The Secretary,
An Coimisiún Pleanála,
64 Marlborough Street,
Dublin 1,
D01 V902,

Case Reference: VA04.324082

The proposed development consisting of a 10 year planning permission for construction of 1 Battery Energy Storage System, 1 110kv AIS electrical substation building and 1 single storey customer substation building

Figure 7-3. Contributors to Cumulative Noise Level, per NSL.

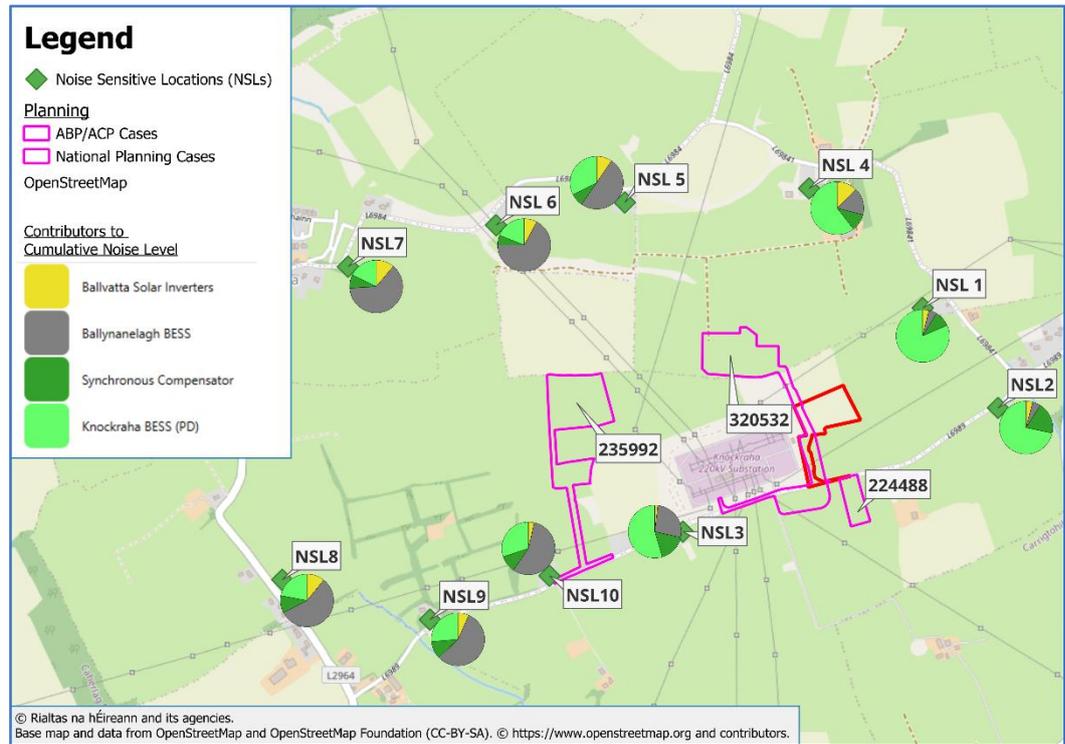
In evaluating the Cumulative Noise Impact Assessment, Enfonic has not considered the modifications to the existing 220kv ESB substation or work associated with the Celtic Interconnector (P22-7.2) in their report. While the engineering works are ongoing as I write this and are almost complete, the increased electrical equipment associated with the 220kv ESB substation and the Celtic Interconnector is not likely to be commissioned until 2027. So, the Enfonic report does not take into account this load to the cumulative noise impact.

Figure 6-1: Typical Drainage and Fire Water Details (Drawing ref. no. 24045-151)

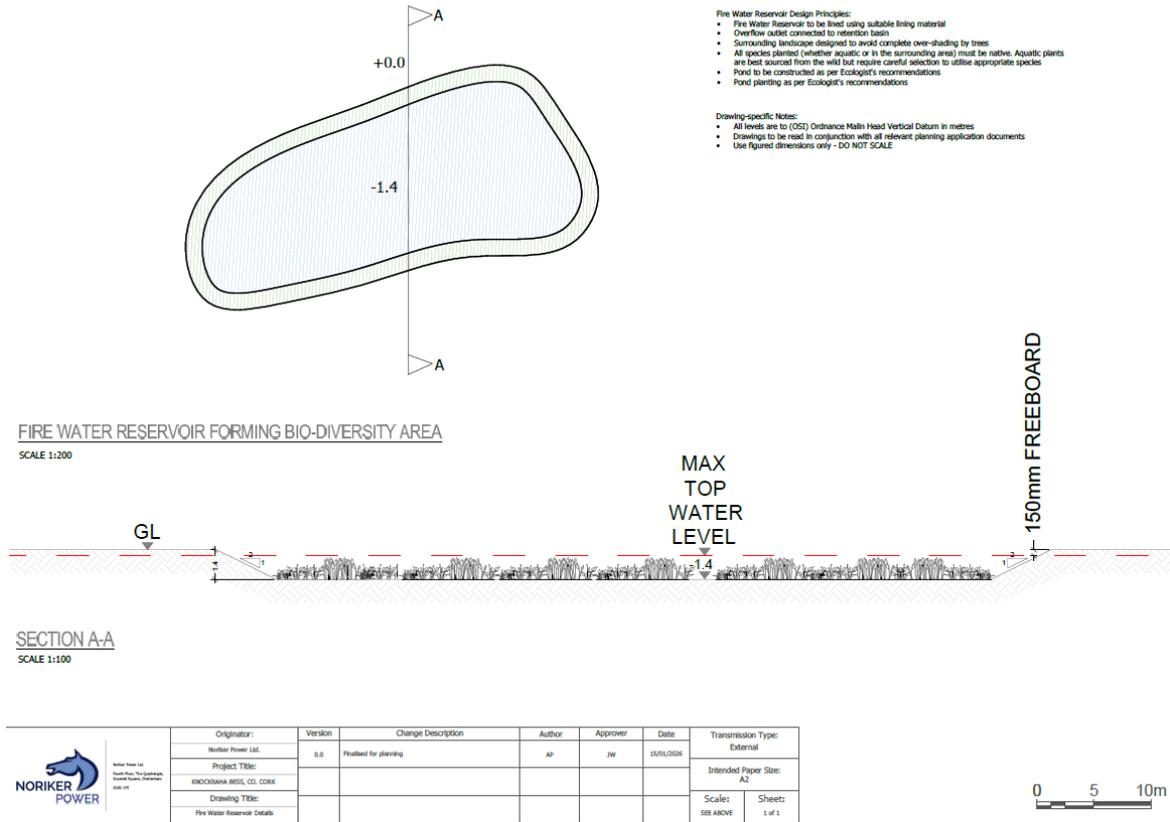
What is the environmental impact of the proposed fire water reservoirs? Considering that a local home west of the site was flooded in Oct 2023 following a day of heavy rains, it comes with some concerns that a reservoir pond filled with 500,000 ltrs stands at the top of the hill.

Prolonged burning is common with some BESS fire events requiring cooling and water application over many hours. Drumkee's proposed solution of a firewater reservoir which will be filled with 500,000 litres of rainwater (approx. 2 hours of water in the event of fire) is inadequate. According to the UK National Fire Chiefs council (NFCC) Grid Scale Battery Energy Storage Systems Planning – Guidance for FRS (Fire & Rescue Services) states that provision should be made for BESS units to provide 1,900 litres of water per minute for 2 hours as a minimum. Considering that BESS fires can last days, I would like to know where all the water for Fire will be ascertained. There are no public water mains on the road L6989.

No details are provided as to how it is proposed to keep the reservoir filled during summer months.

ORS recommends fire -hydrants near this reservoir but these are not identified in the plans submitted.
